ADDENDUM TO MINOR MODIFICATION OF PROJECT APPROVAL MP09_0025

This letter forms an addendum to the current application to undertake a minor modification to Project Approval MP09_0025. This addendum seeks to clarify the details of the minor modification application with reference to the Project Approval requirements and in response to issues raised during the public advertising period with respect to the design, appearance and layout of the sites.

Please find attached a drawing set, **Drawings EV01 – EV16, Issue E**, that has been prepared to clarify the changes to the design, appearance and layout of the sites as described below. The proposed amendments are consistent with Project Approval MP09_0025 and have occurred as a result of detailed design of the facilities, in consultation with the facility operator.

EAST ELEVATION

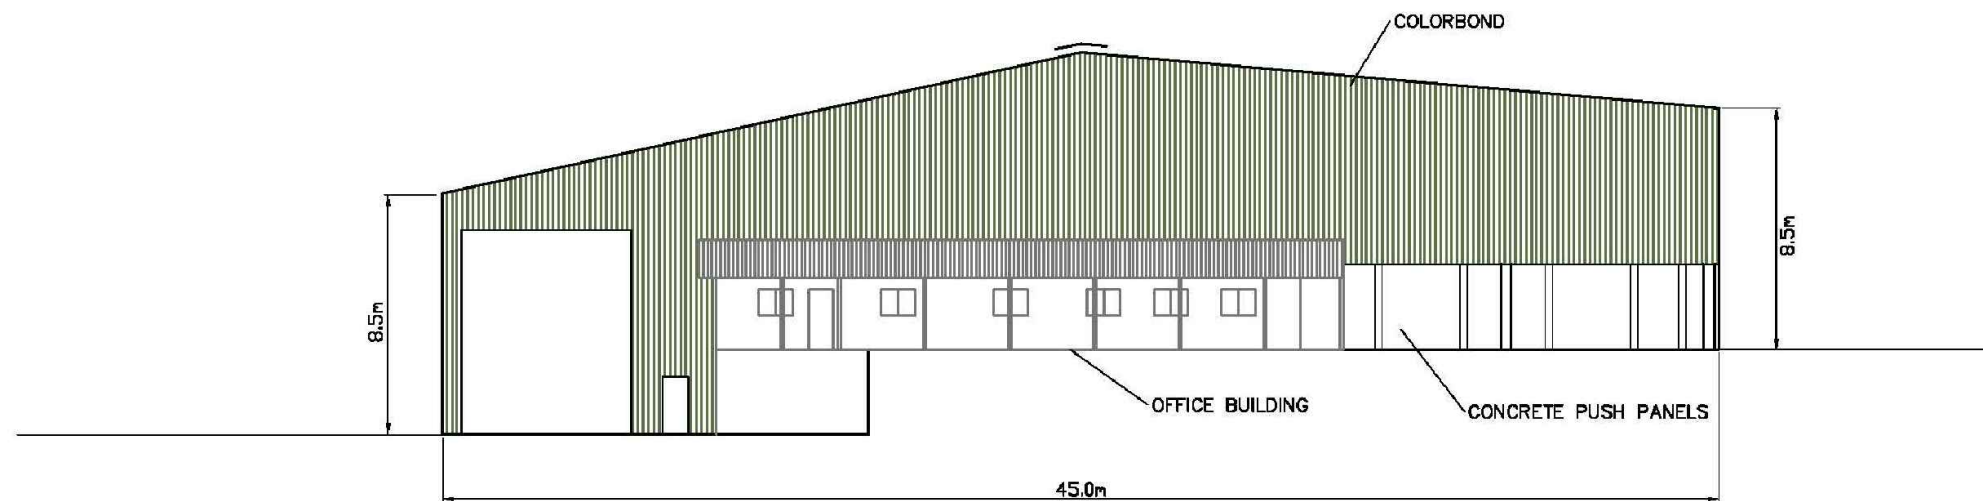
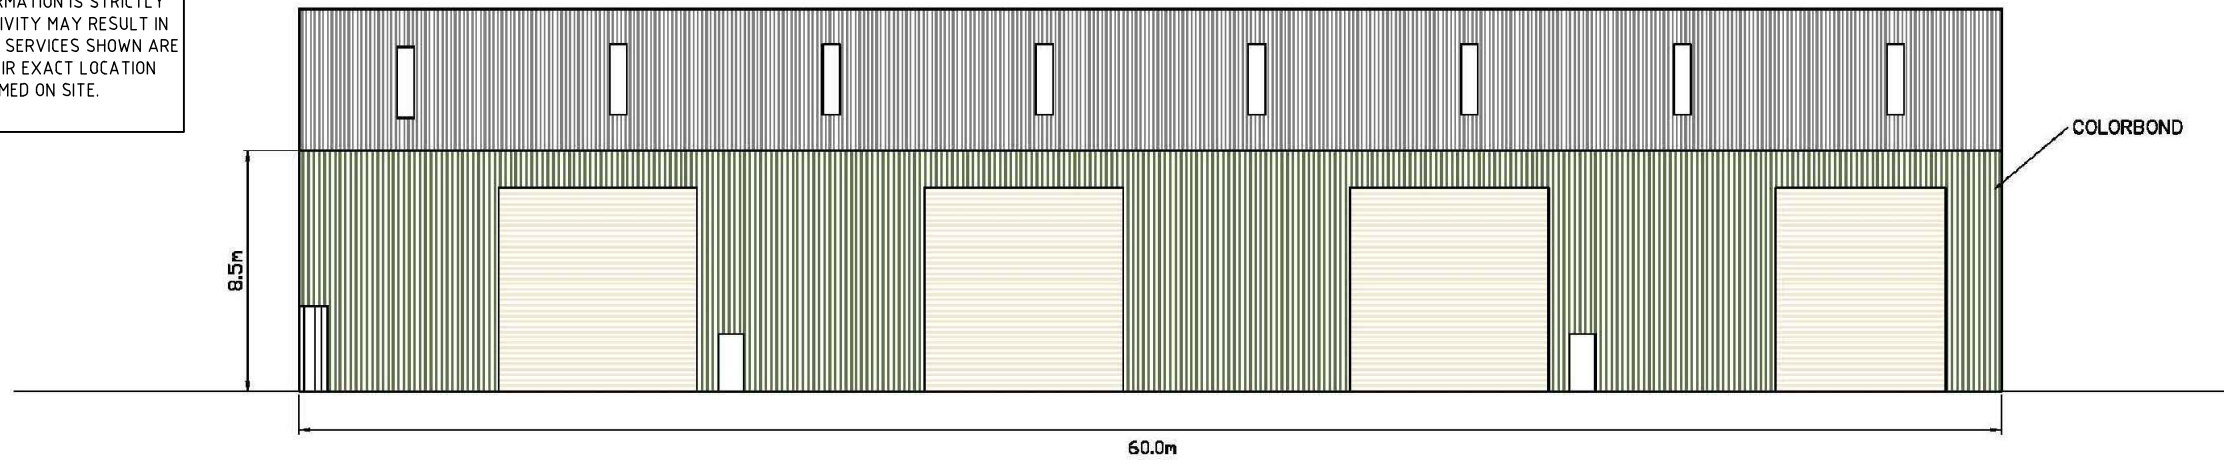
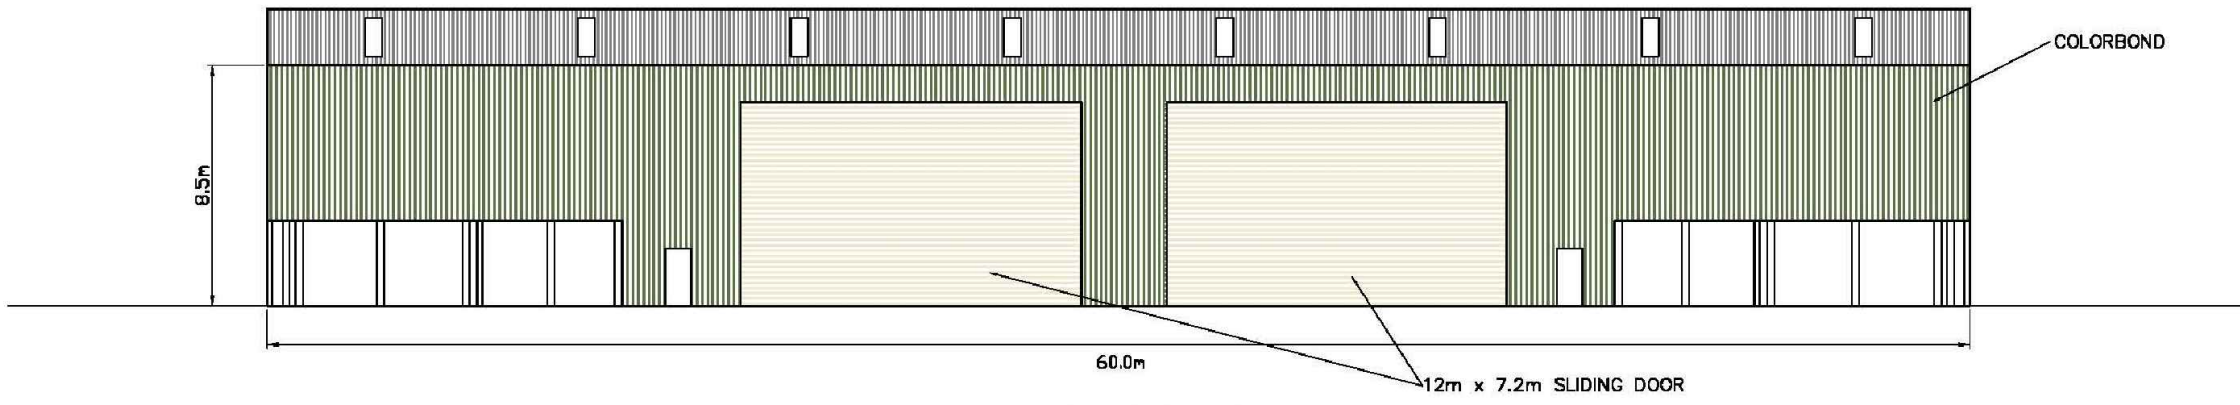
The Residual Waste Baling and Food and Garden Organics Building at Ophir Road is subject to a minor change by comparison to the drawings submitted with the minor modification application, being an increase of wall height by 500 millimetres. Despite the increase in wall height, the overall height of

the building will be reduced by 1 metre, from 13 metres to 12 metres, due to a reduction in roof pitch from 15 degrees to 10 degrees on the northern roof plane and a reduction in building width from 50 metres to 45 metres. This width reduction also results in a reduction in the building footprint from 3000 square metres to 2700 square metres.

It is proposed that the Residual Waste Baling and Food and Garden Organics Building would feature walls of a light green hue (Colorbond® Pale Eucalypt) in line with the commitments of the project approval, however the roof would be grey (Colorbond® Dune) and the doors and shutters would be light brown (Colorbond® Paperbark), as shown on **Drawings EV05** and **EV06**. It is considered that this variation and use of complimentary colours would provide visual relief to better integrate the building into the landscape.

PROJECT NUMBER: 208212	DRAWING NUMBER: 24_ EV13	REV: E
SOURCE: SIX VEI/ER

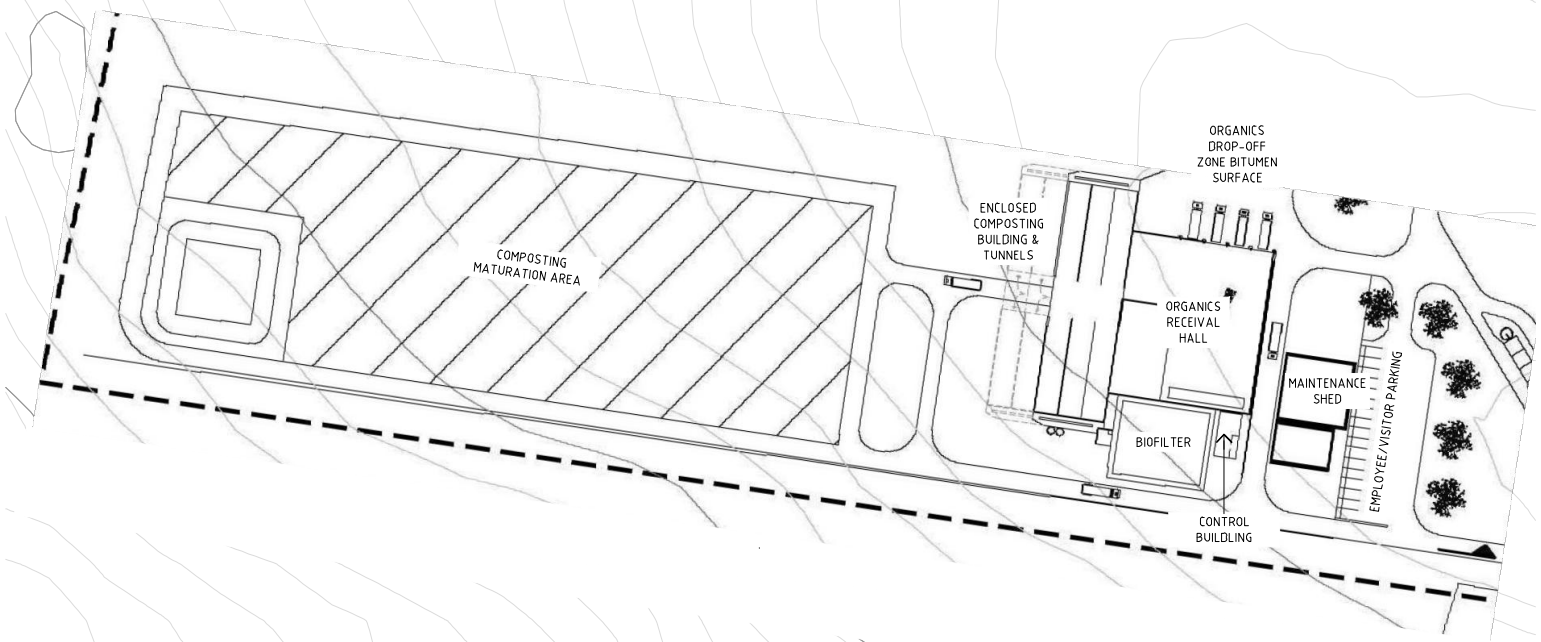
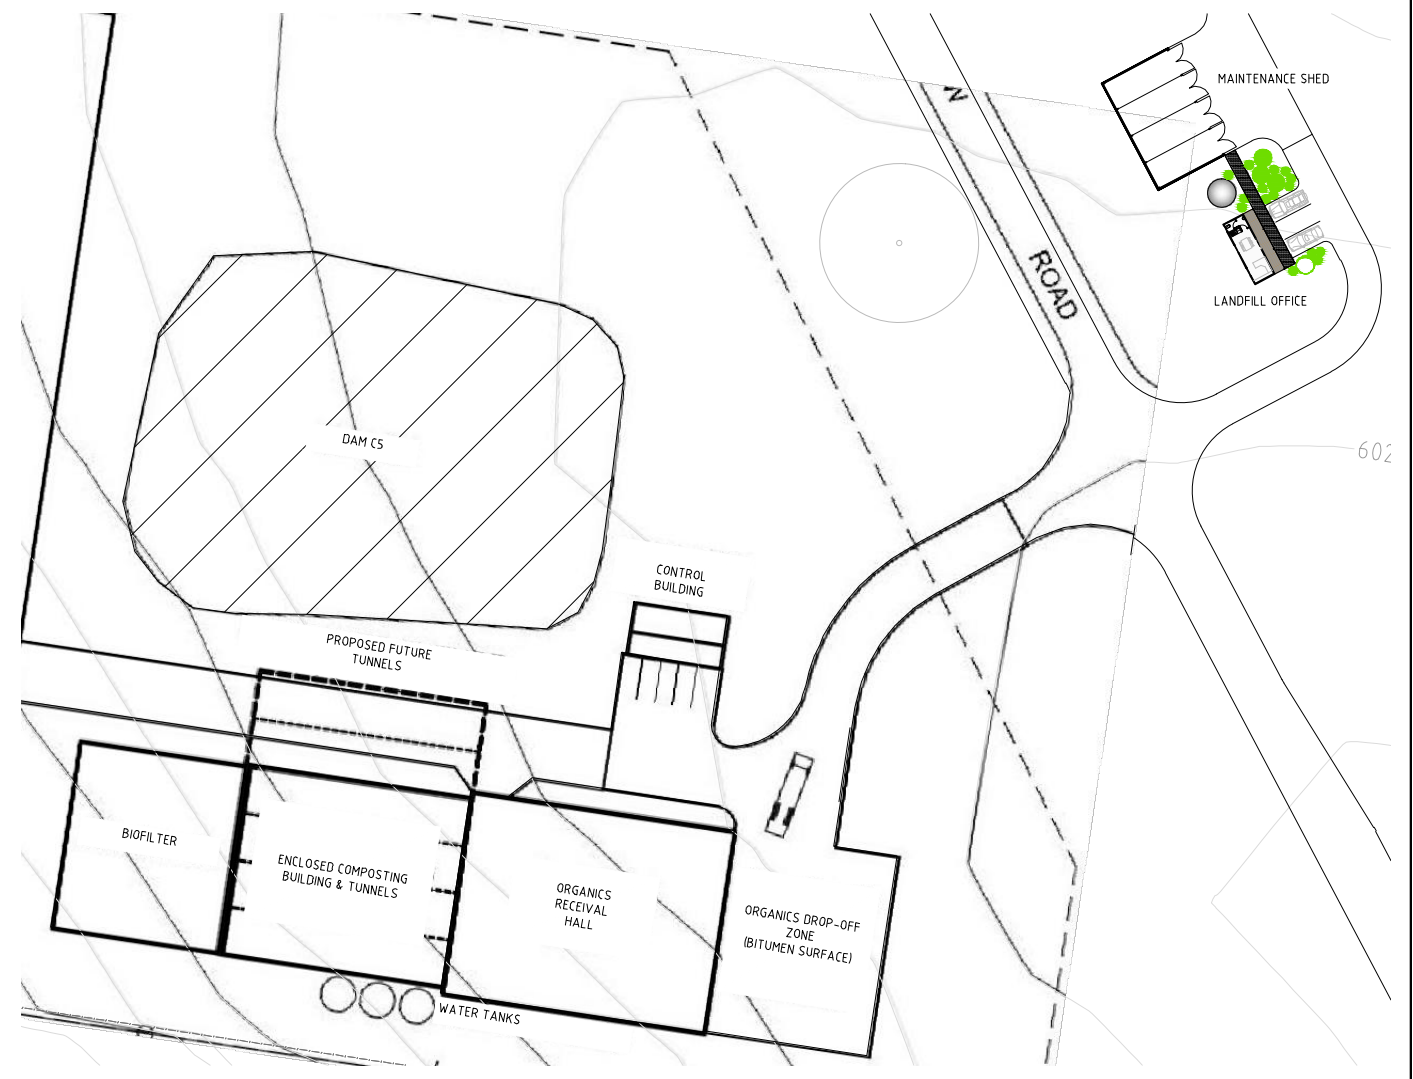
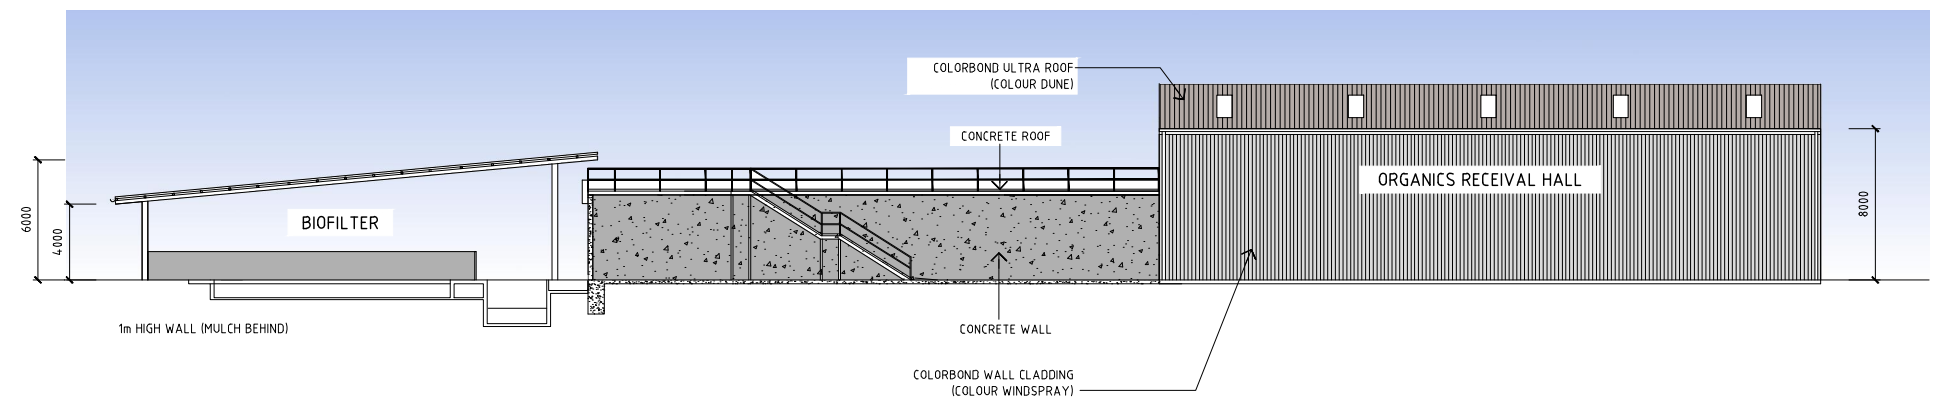
The two dams relating to land fill operations would remain, however following the completion of detailed design, the size and location is proposed to be slightly modified, as shown on **Drawing EV13**. It is not anticipated that this minor modification will have any detrimental impact on water function at the site.
